Ribble Valley Borough Council  
Housing & Development Control

Application no: **3/2024/0028**

Address: **Seedalls Farmhouse Eaves Hall Lane West Bradford Clitheroe BB7 3JG**

Proposal: **Change of use of domestic garage and store to two-bedroom holiday accommodation.**

Seedalls Farm, Leaves Hall Lane, West Bradford, BB7 3JG		19 02 2024
For Mr. & Mrs J Evans		0076
Conversion of garage to holiday let		PL 00 04A
PROPOSED PASSING PLACE

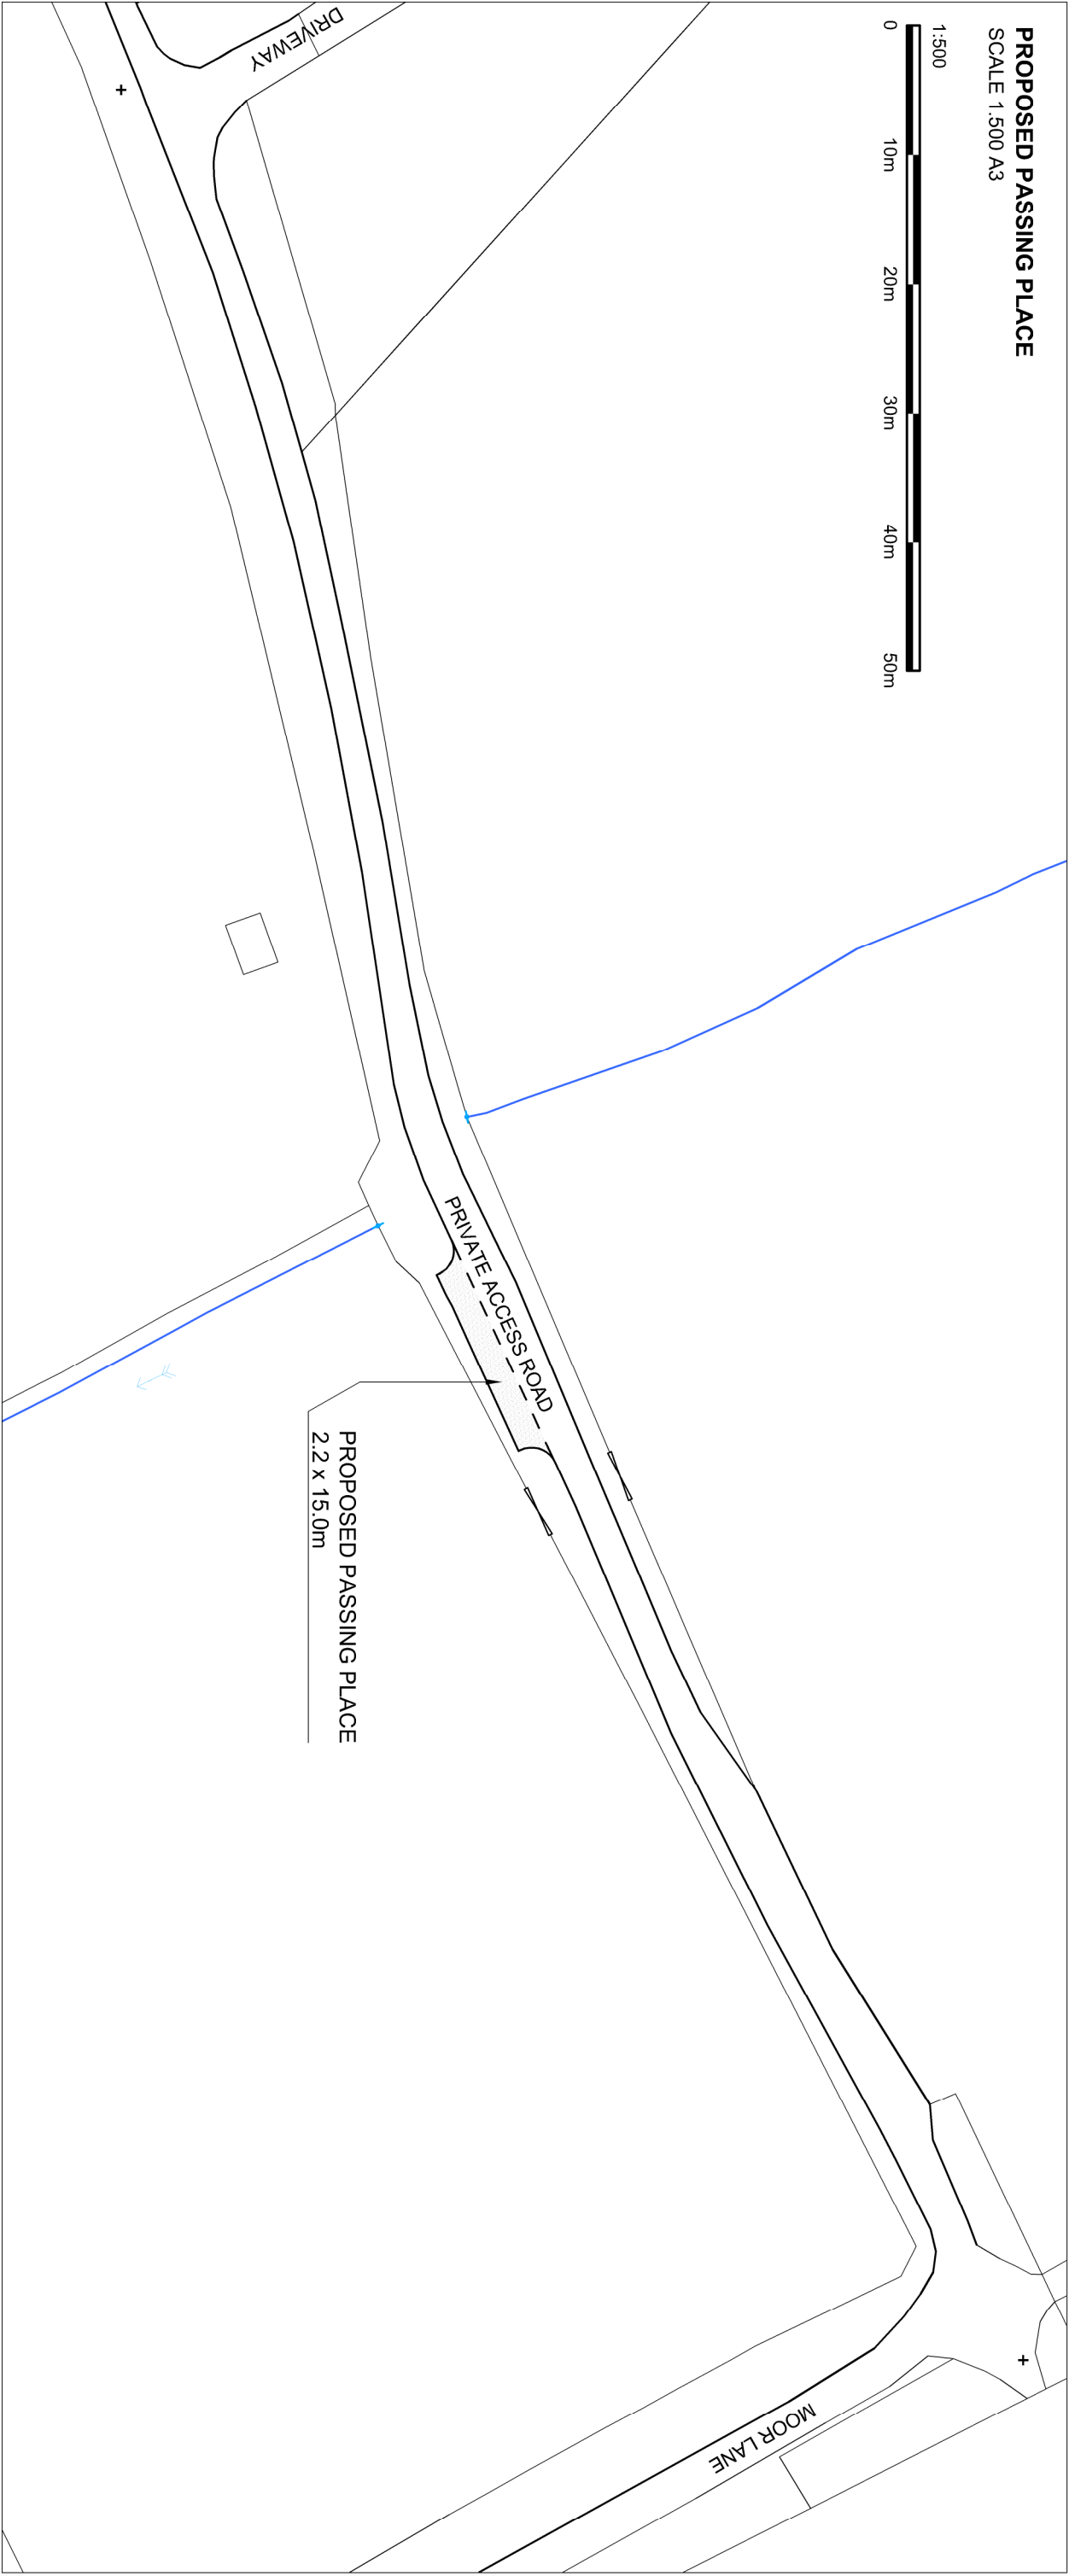
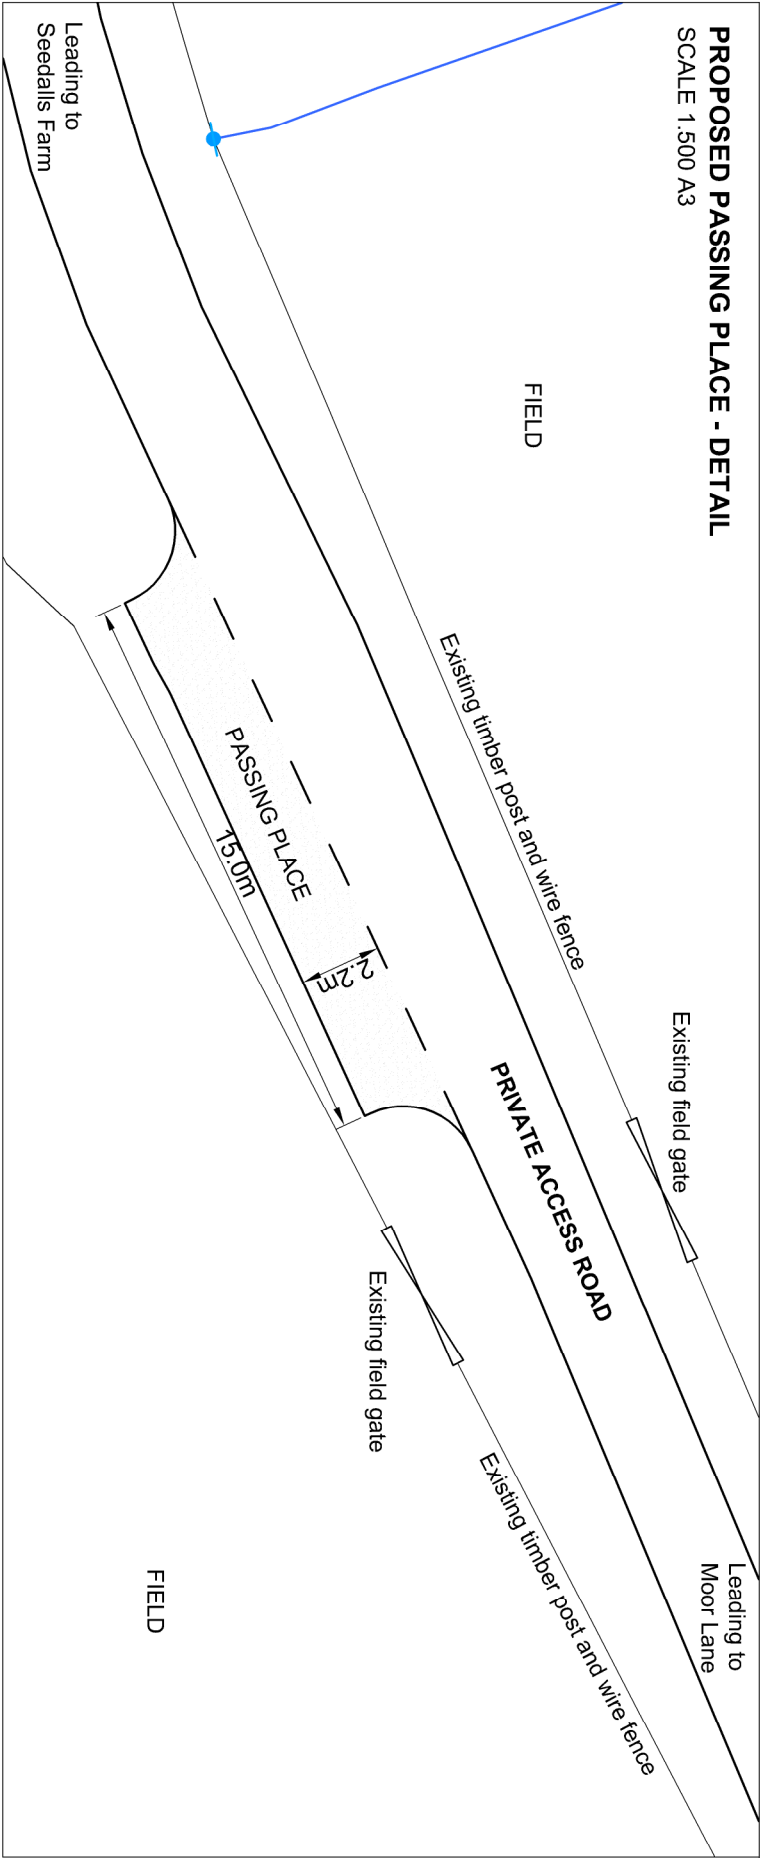
The LHA will however, request that the unadopted access track which serves the farm and Public Footpath FP0344007, provides a minimum of one passing place along its length. The passing place should be a minimum of 2m x 15m in length, given that agricultural traffic will continue to use the track when servicing the farm. This passing place should be shown on a revised plan.

- A minimum of one passing place measuring 2m x 15m in length along the unadopted, access track which serves the site.
- Cycle storage facility for the holiday cottage.
